**From:** Richard Temple  
**Sent:** 06 December 2017 09:59  
**To:** Karen Parsons  
**Subject:** FW: Y/65/17/HH Rumford, Church Road

**ADC Planning Consultation  
Conservation/Design Officer Response**

| <b>Application Number</b> | <u>Y/65/17/HH</u>                                                                                                                                                                          |
| <b>Description</b>        | Buttressing & repair of failed flint wall. This application affects the setting of a Listed Building & the Character & Appearance of the Yapton (Main Road/Church Road) Conservation Area. |

Flint wall repair Proposed Plan and section

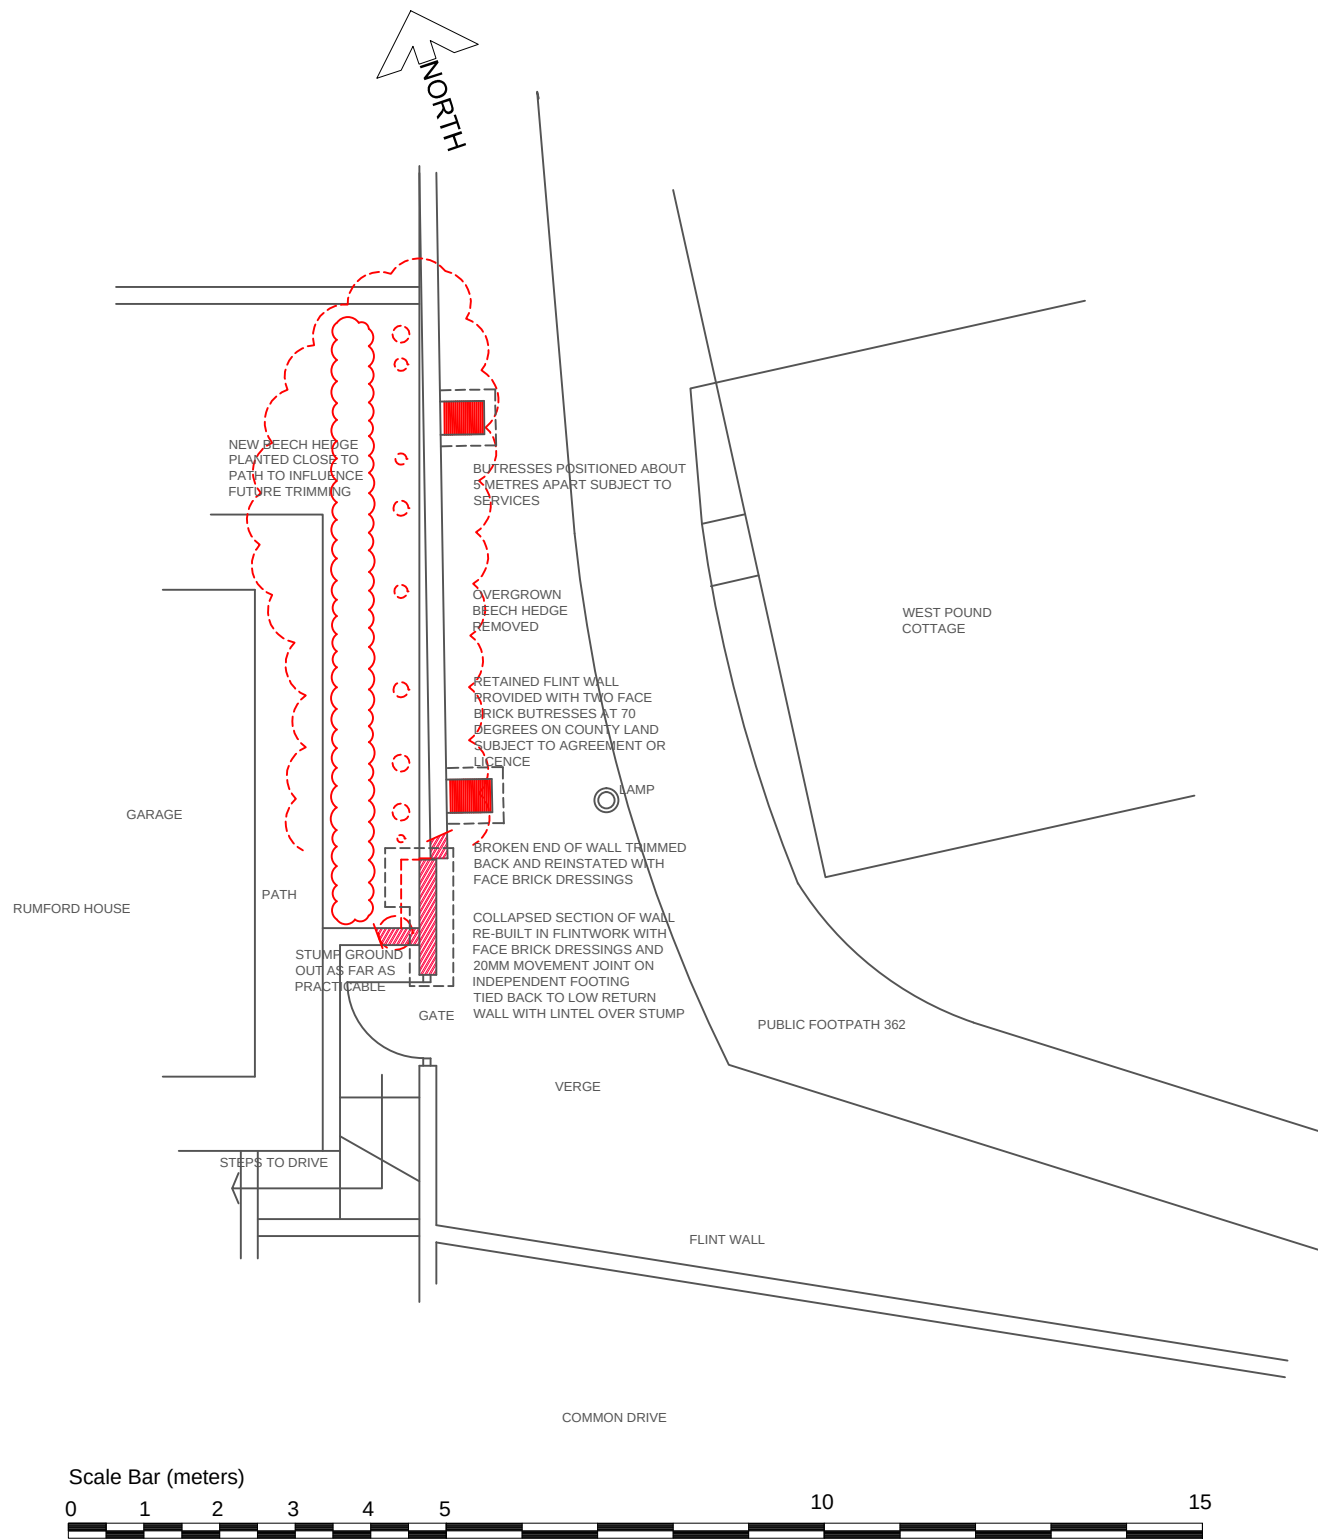
A section of the wall has collapsed, and submitted plans show the insertion of brick facings between existing and new flint work, a movement joint, together with the insertion of 2no. brick buttresses in concrete footings.

While there is no objection to the repair of the collapsed section of wall, in suitable lime mortar, re-using the flint cobbles, it is not normal practice to insert a brick facing, nor piers, nor piers in a foundation as drawn. It is considered that the proposed is visually intrusive and upsets the visual harmony of the run of wall, and therefore I object to this application.

It is suggested that the collapsed section of wall is rebuilt using suitable lime mortar, with existing cobbles, capped to match existing. Should a structural survey suggest increased structural support is deemed necessary, the use of Helifix or a similar could be considered within the core of the wall. Any structural issues that are found to exist should be ascertained by a suitably qualified person, and be addressed accordingly via the usual process.
